REFUSAL OF PLANNING PERMISSION

APPLICATION NO. 2018/0462

Proposal Erection of first floor side extension to dwelling
At 60 Manchester Road, Thurlstone, Sheffield, S36 9QT

HOUSE EXTENSION 60 MANCHESTER ROAD THURSTONE
 PLAN , ELEVATIONS 1:100 3/2018 DRG A1
 REVISD NORTH
 ELEVATION 5/2018

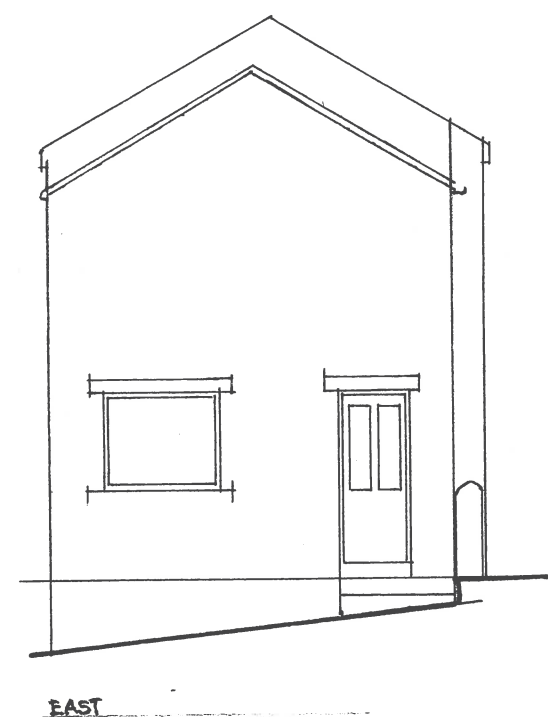
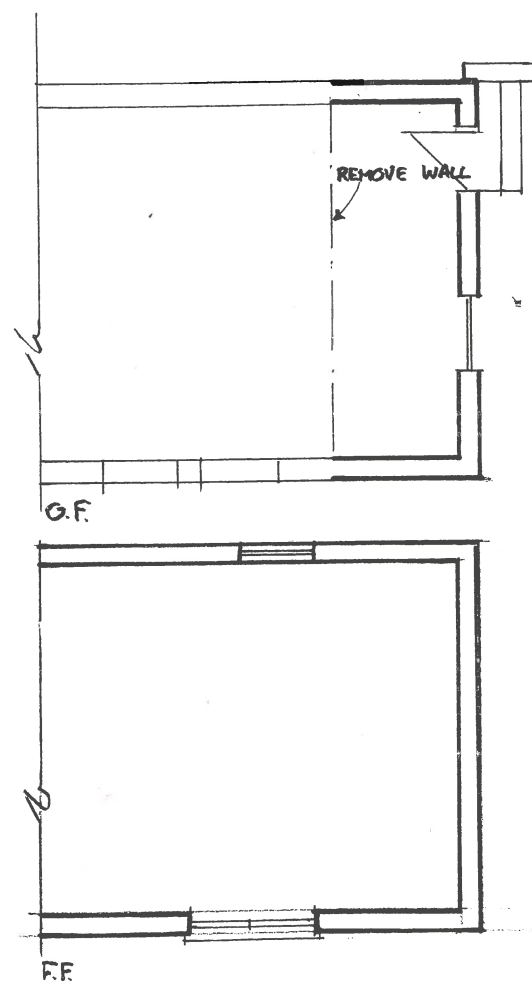
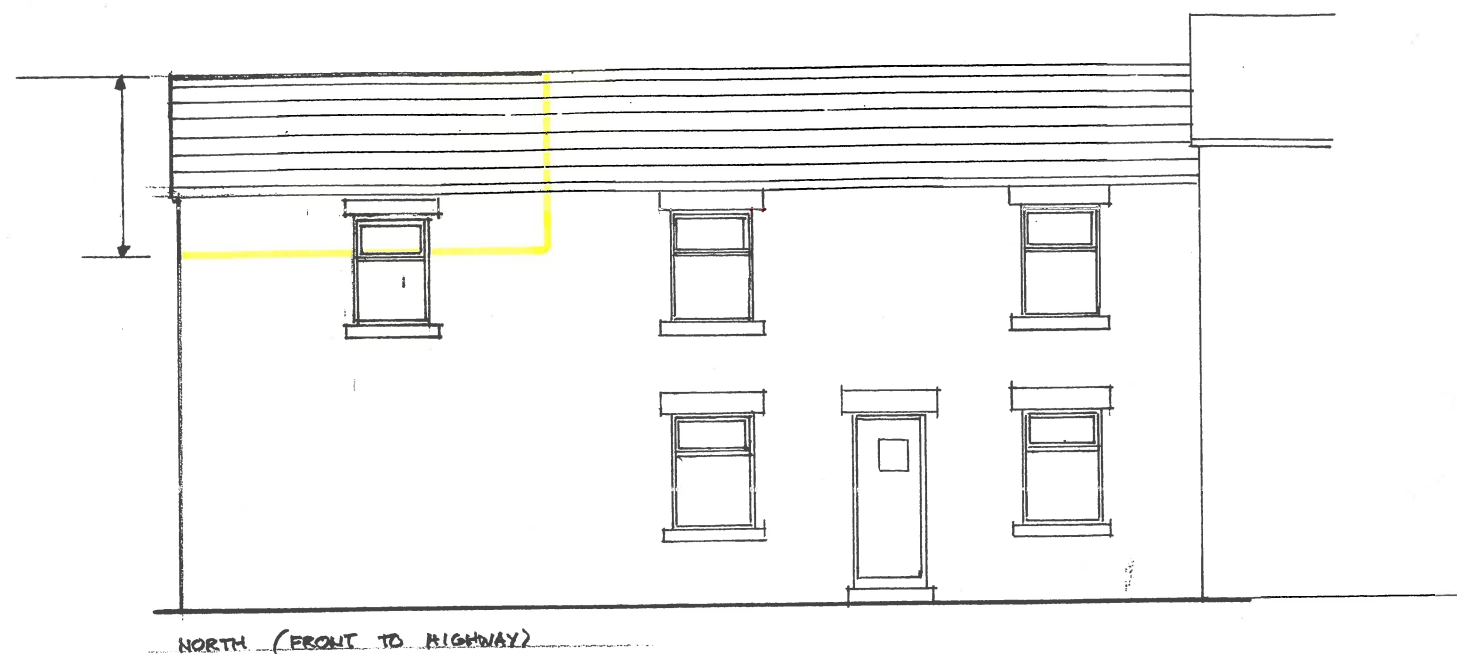
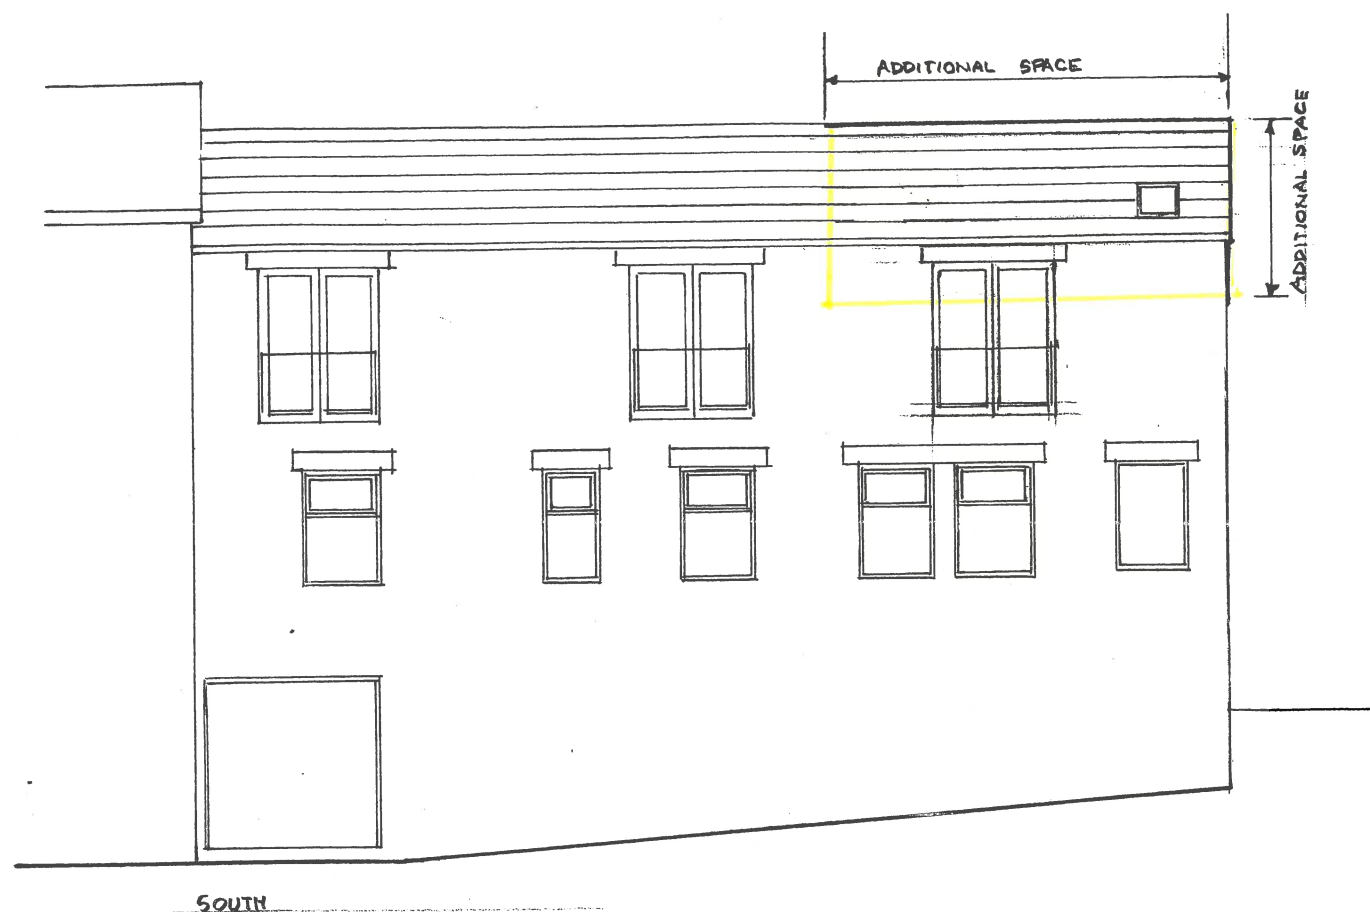
- 1 In the opinion of the Local Planning Authority the proposed extension would be contrary to Core Strategy policies CSP29 'Design, CSP30 'The Historic Environment' and the House Extensions SPD in that the width, height and fenestration details of the proposal would fail to harmonise with the original dwelling as it would no longer remain the dominant feature. As such the development would have a harmful impact on the character and appearance on the Thurlstone Conservation Area.
